DRB Application No.: 03DRB-01547 ²⁰¹⁴ Project # 1002518
 Project Name: Alvarado Farms EPC Application No.: 1001753
 Agent: Comm. Sciences Phone No.: 259-0883 Jan

4. Project # 1002518

03DRB-02014 Major-Vacation of Pub Right-of-Way
03DRB-02015 Major-Vacation of Public Easements
03DRB-02016 Minor-Amnd Final Plat Approval

COMMUNITY SCIENCES CORPORATION agent(s) for THOMAS & MARGARET KRYFKO, TEDDY & BARBARA POLK & GWENDOLYN VANDAMME request(s) the above action(s) for all or a portion of Lot(s) 41, **ALVARADO GARDENS, UNIT 3**, zoned RA-2, located on DECKER AVE. NW, between GLENWOOD ROAD NW and TRELIS DR. NW containing approximately 1 acre(s). (G-12)

**PLAT OF  
LOTS 41-A & 41-B  
ALVARADO GARDENS  
UNIT 3**

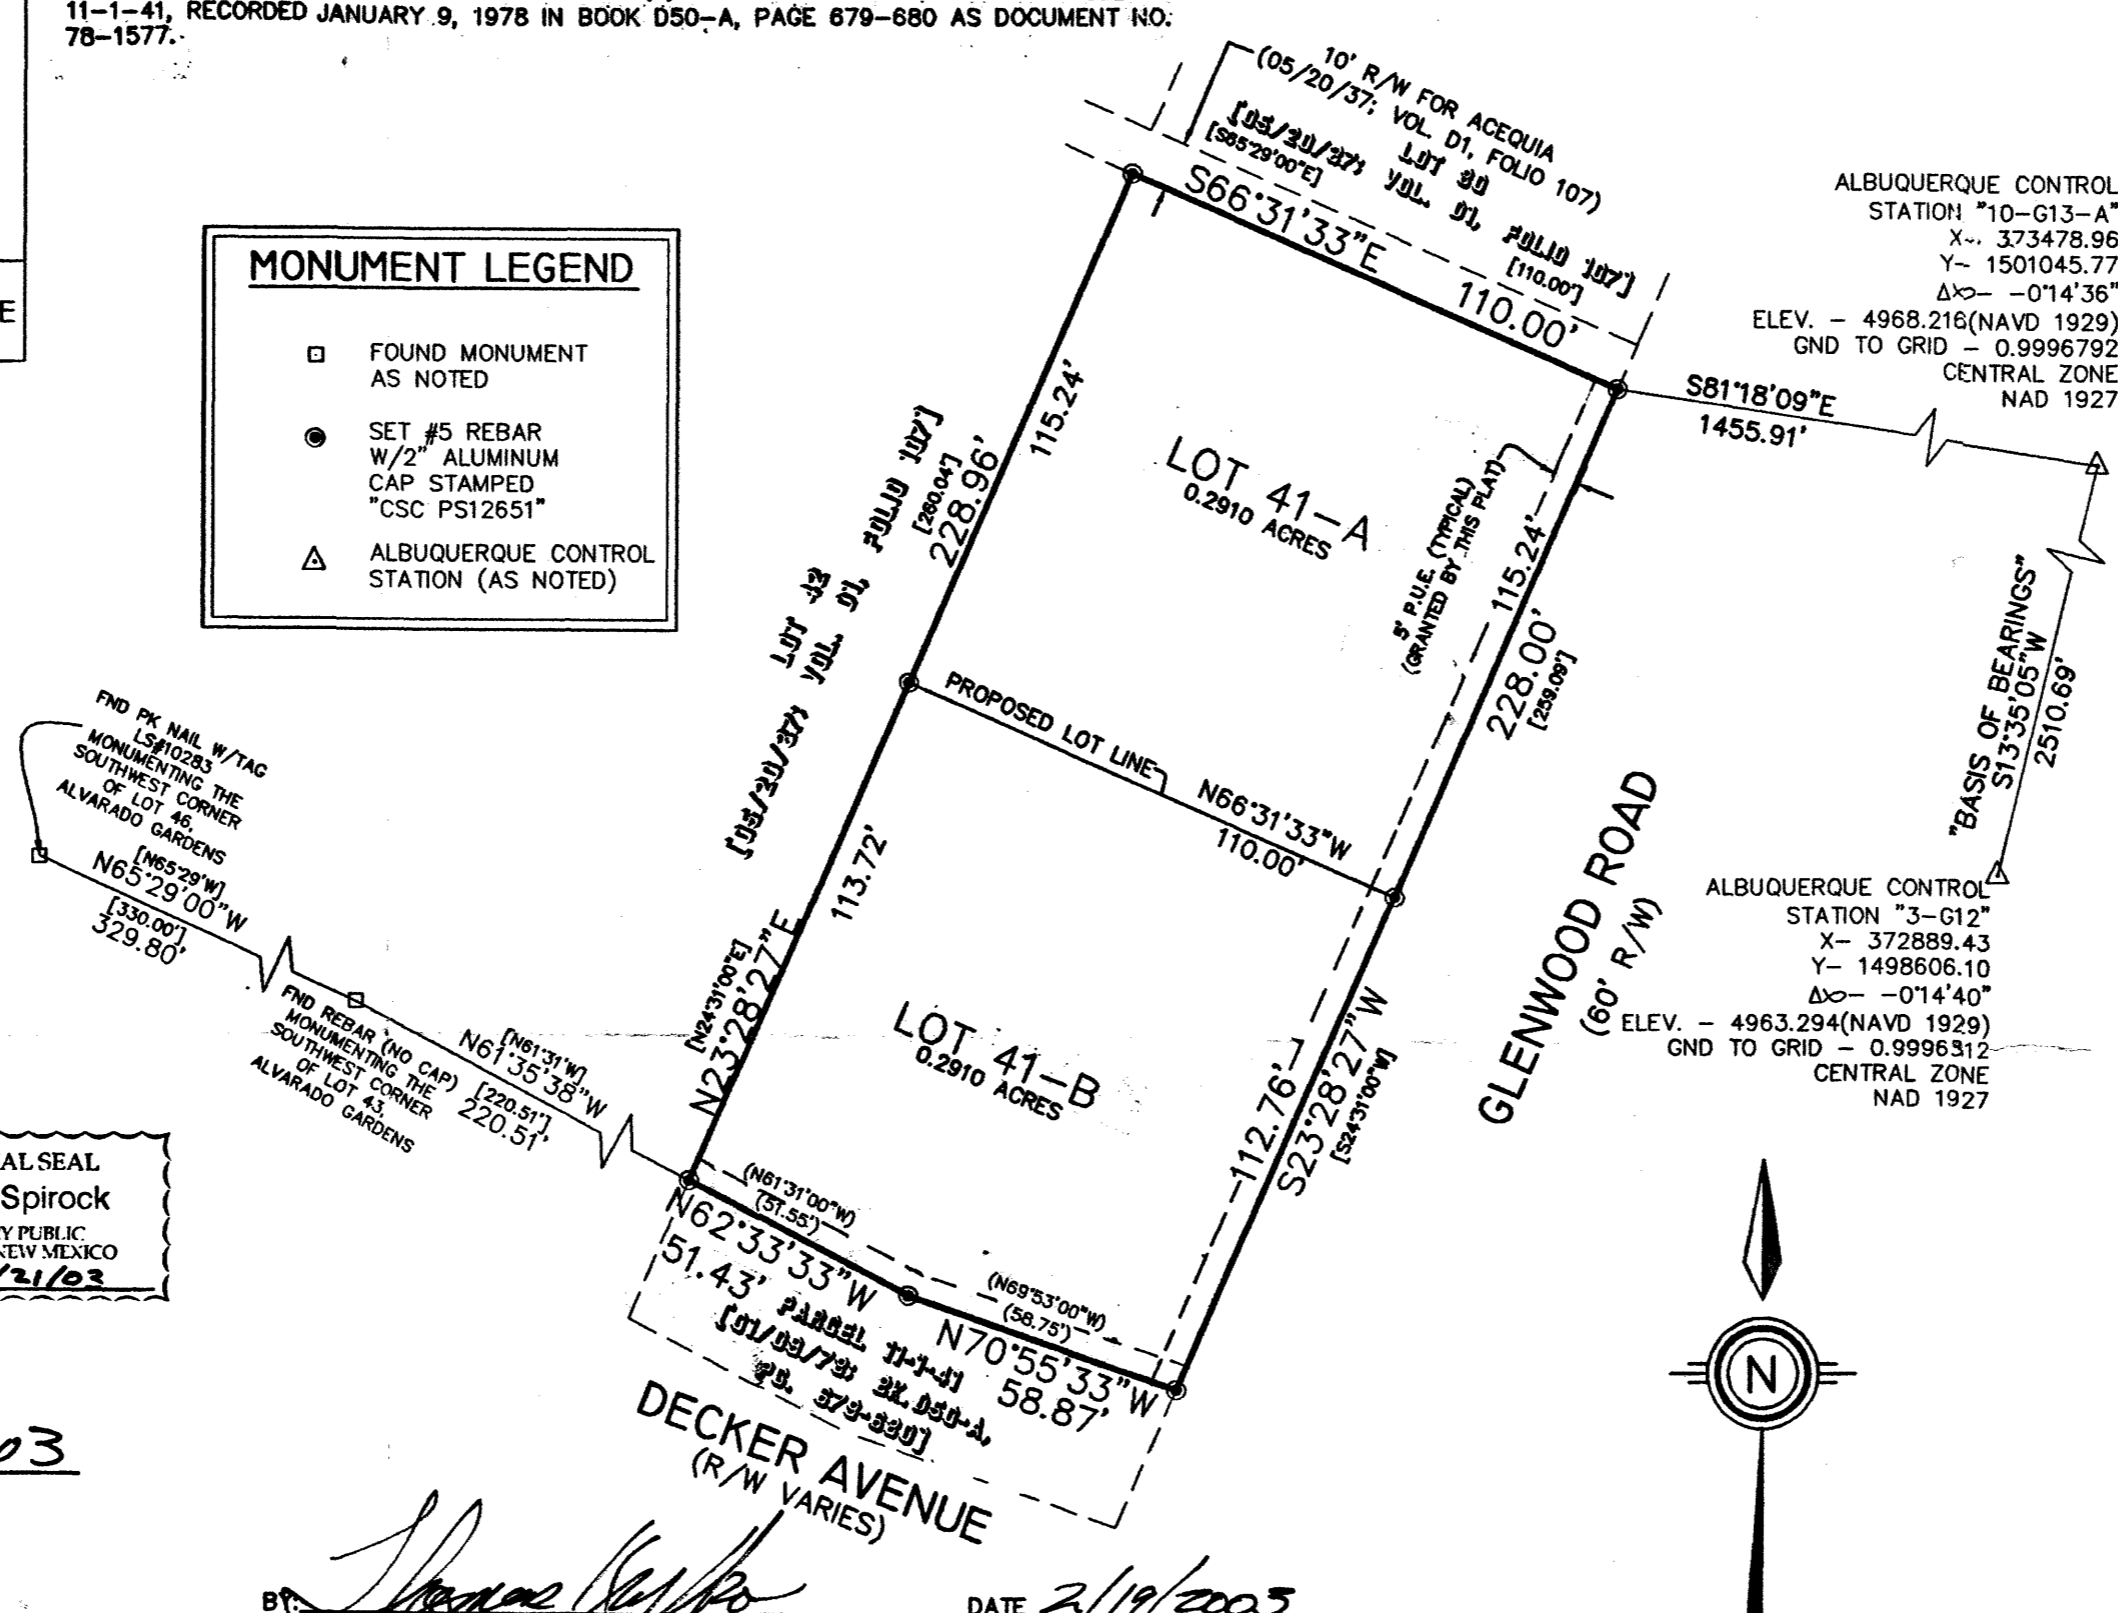
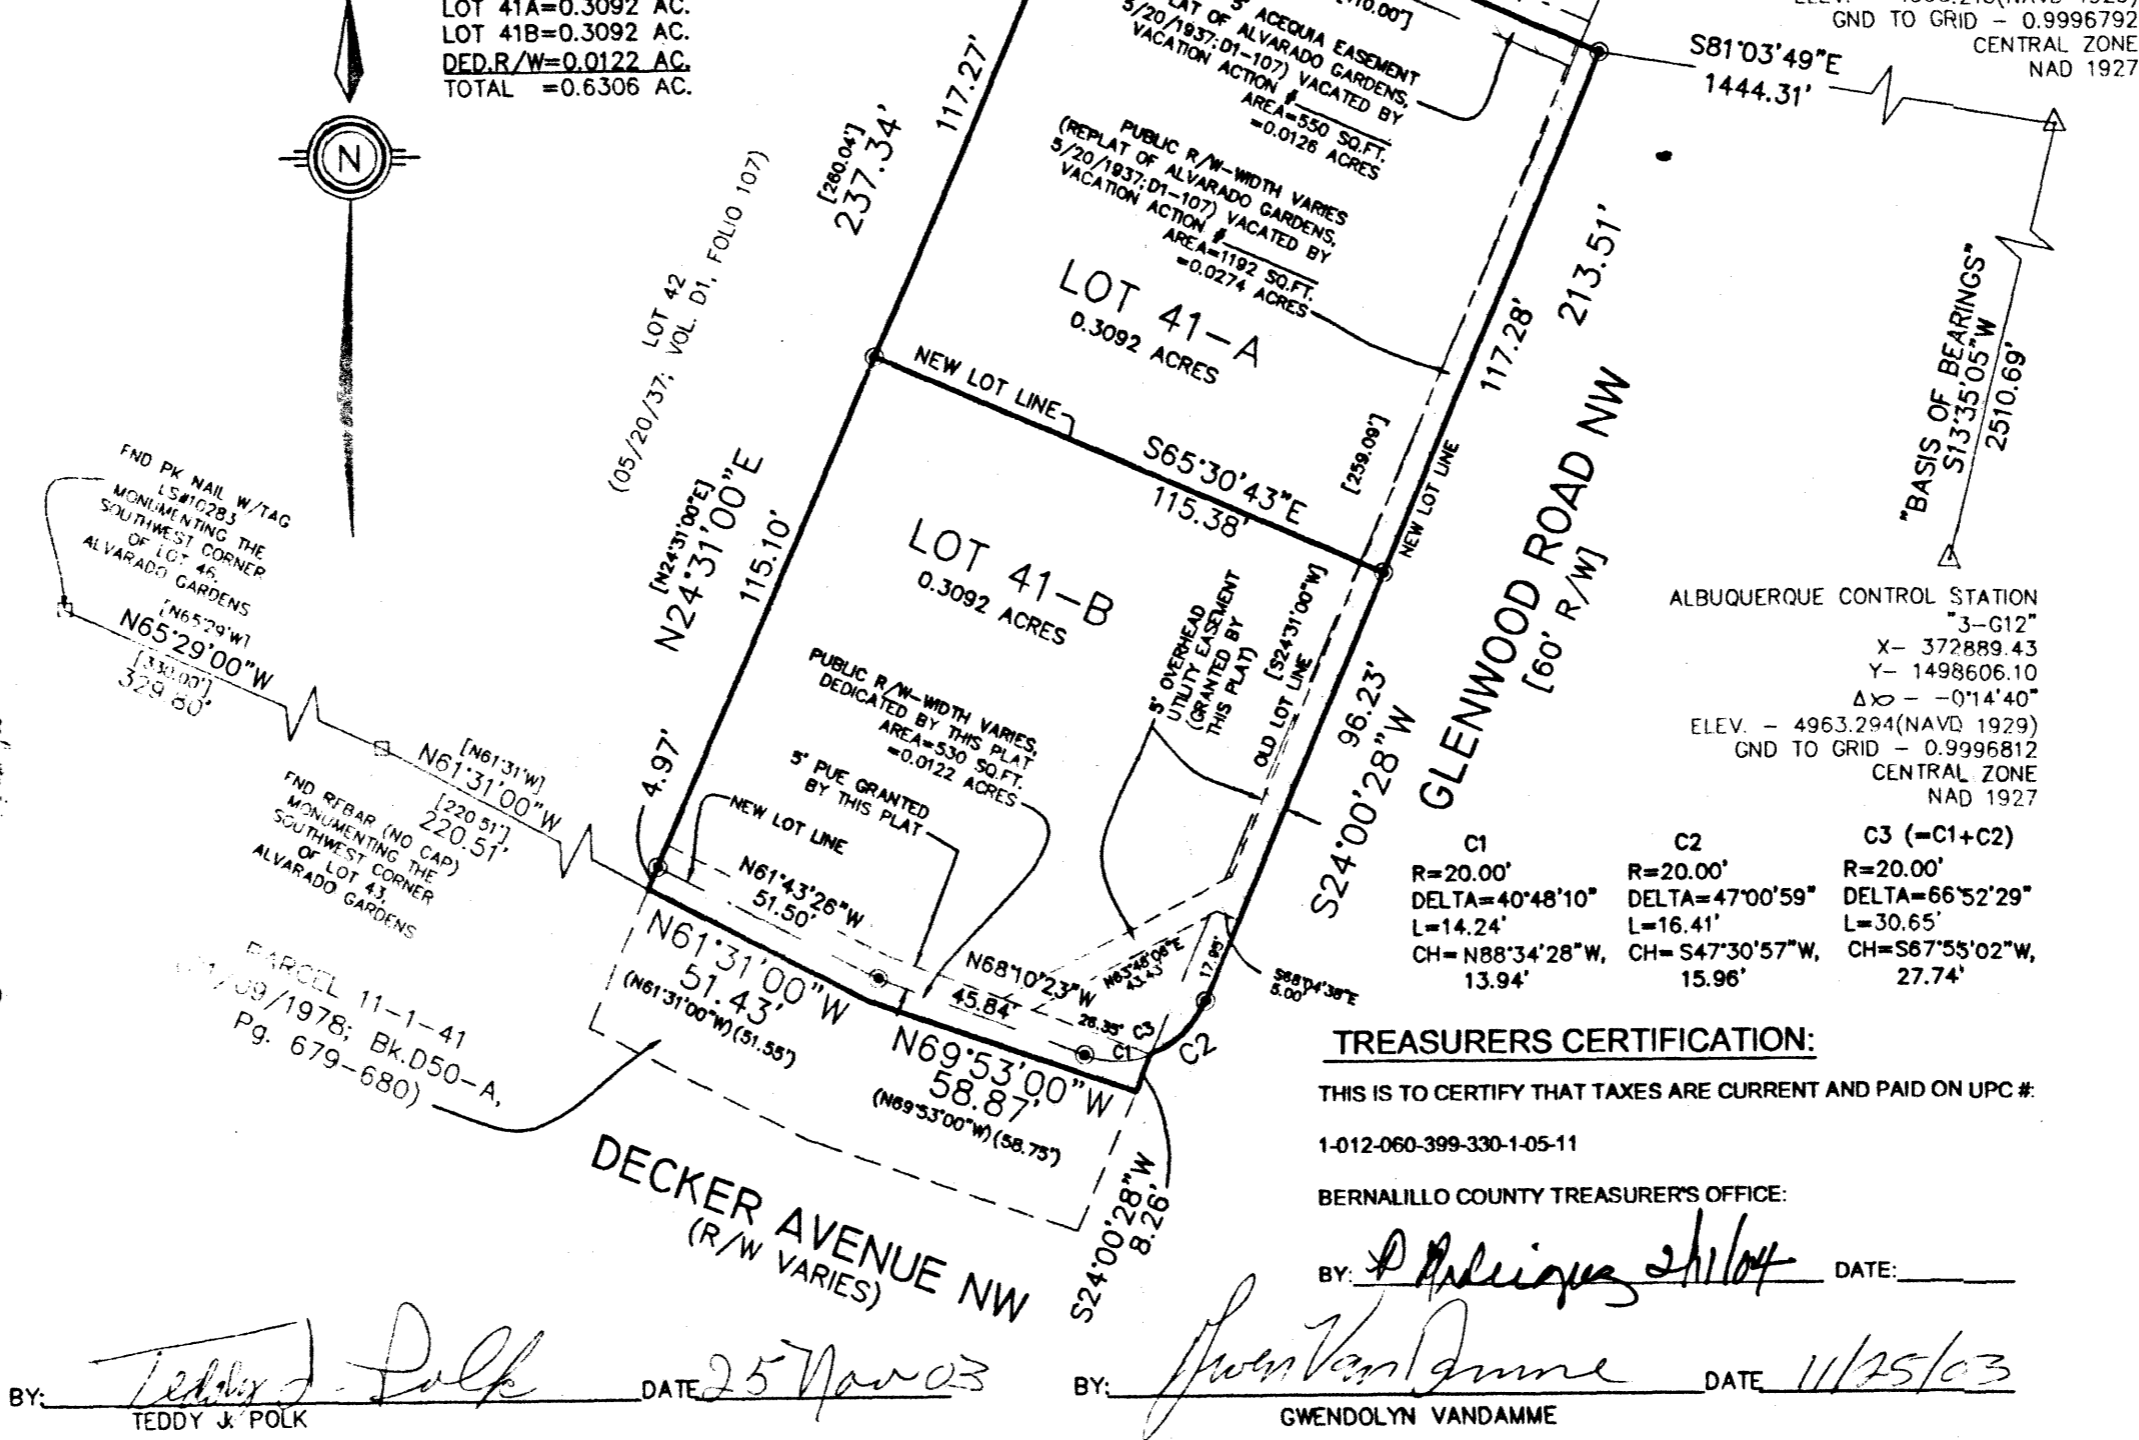
MRGCD approval of vacation required – they must also sign plat prior to City Engineer. No objection to street vacation.

- 1) Is the sidewalk constructed?
- 2) Provide sketch-showing face of curb in relation to the new property lines on both Decker & Glenwood.
- 3) Are all PUE's now located on private property?
